Your Ref: OWPC18920
Our Ref: WA/49/18/PL 02-05-2018
Please ask for:
Andrew Wood

Demolition & erection of 1 No. dwelling.
The White Cottage West Walberton Lane Walberton

Proposed New Dwelling
at White Cottage, West Walberton Lane, Walberton
for Mr. and Mrs. A. Wickland
Drawing P11 April 2018 Scale 1:100 & 1:500 @ A3
Planning Drawing - Proposed First Floor Plan & Block Plan

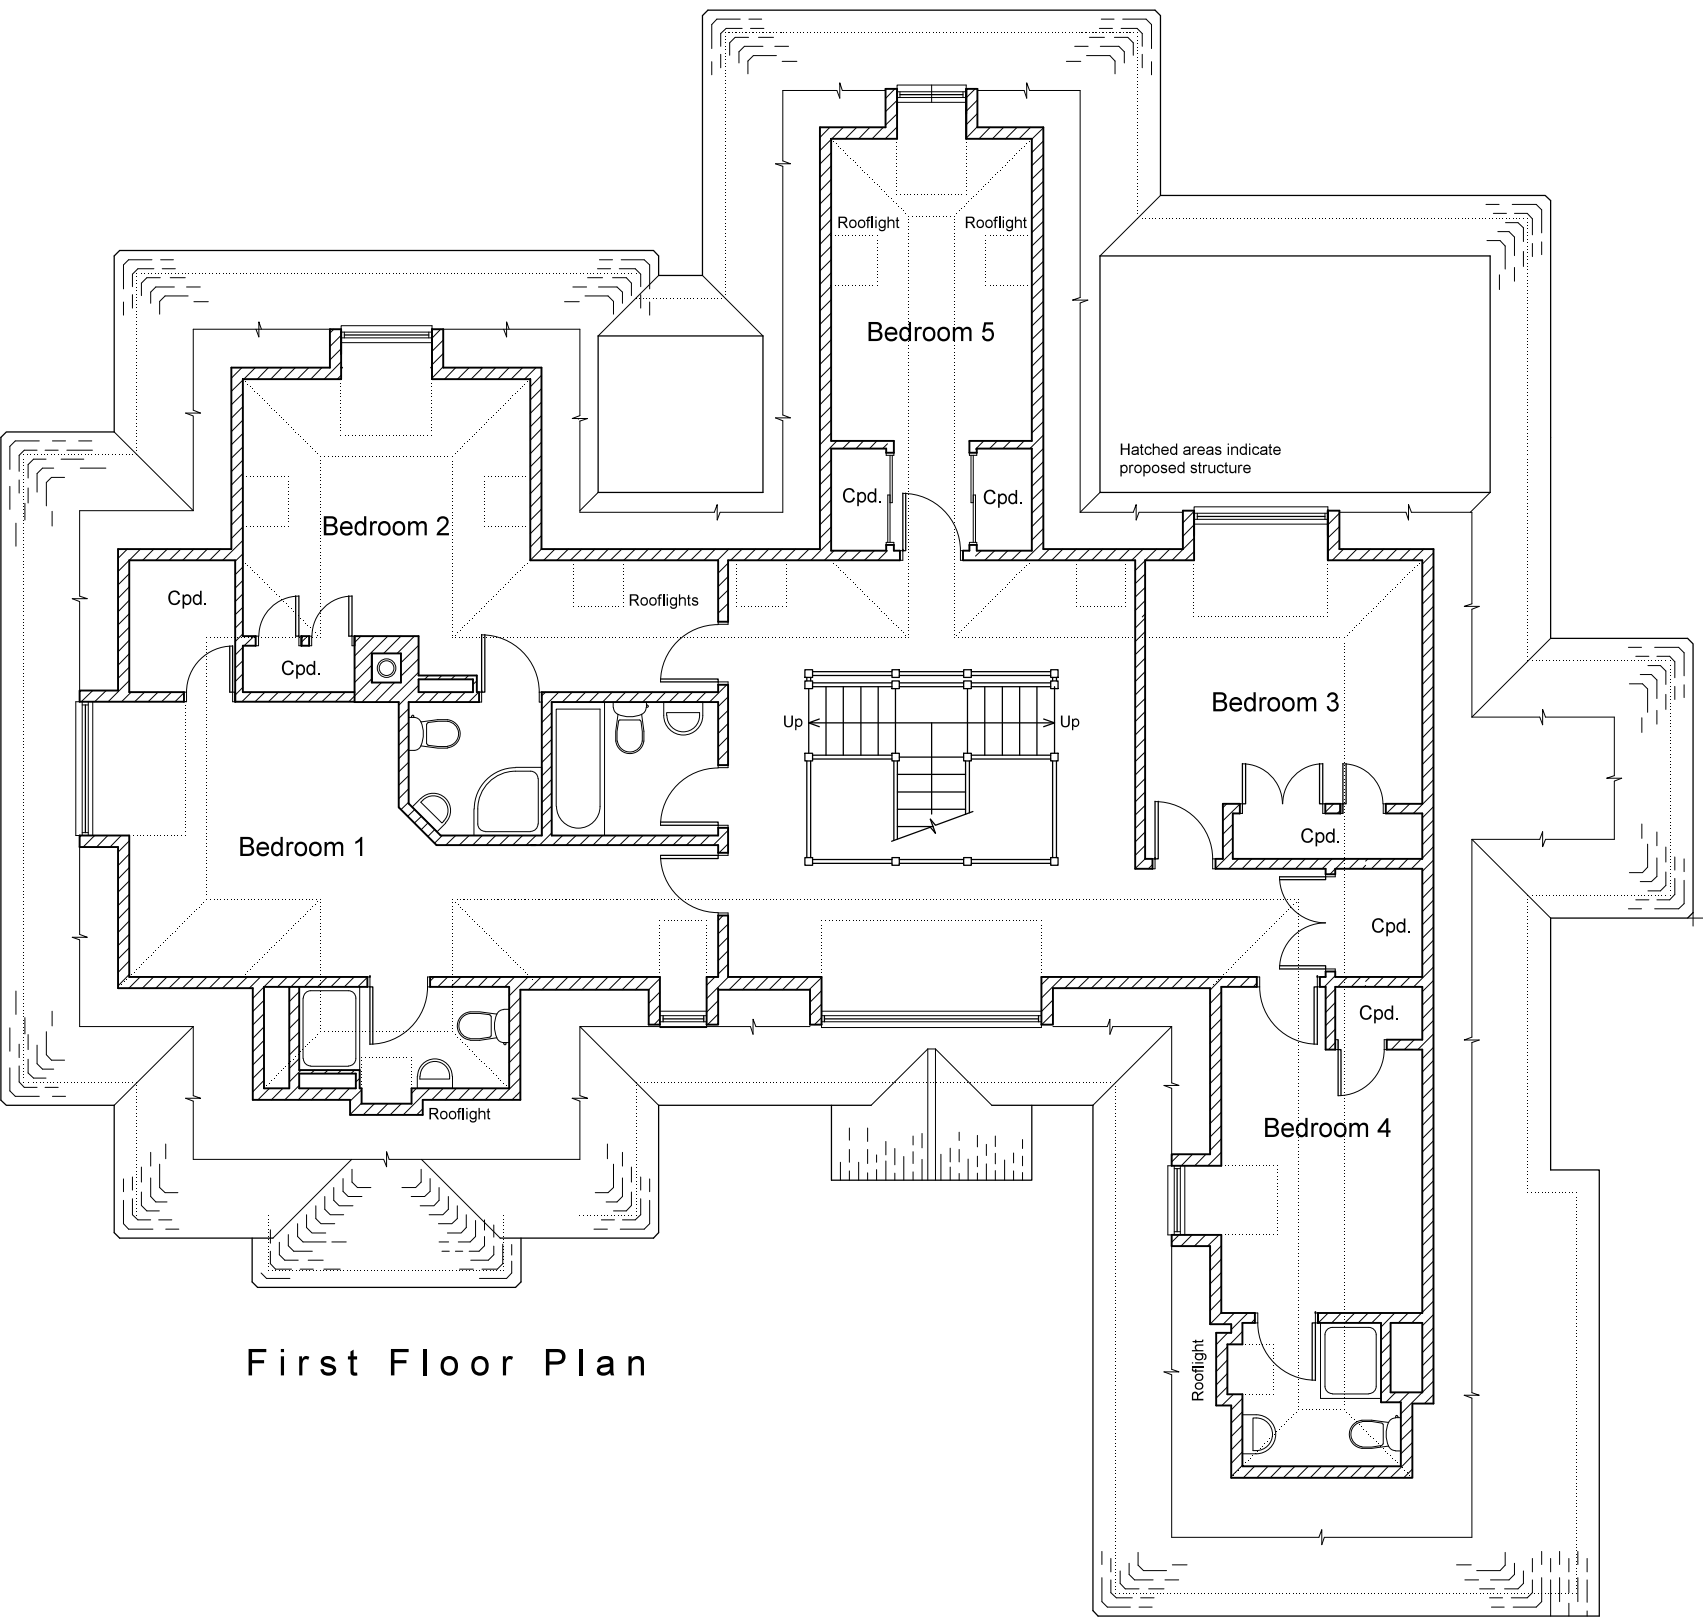
A bedroom window, sited on the East elevation at circa 5 metres, overlooks the neighbouring property. Currently there is no window or loss of privacy.
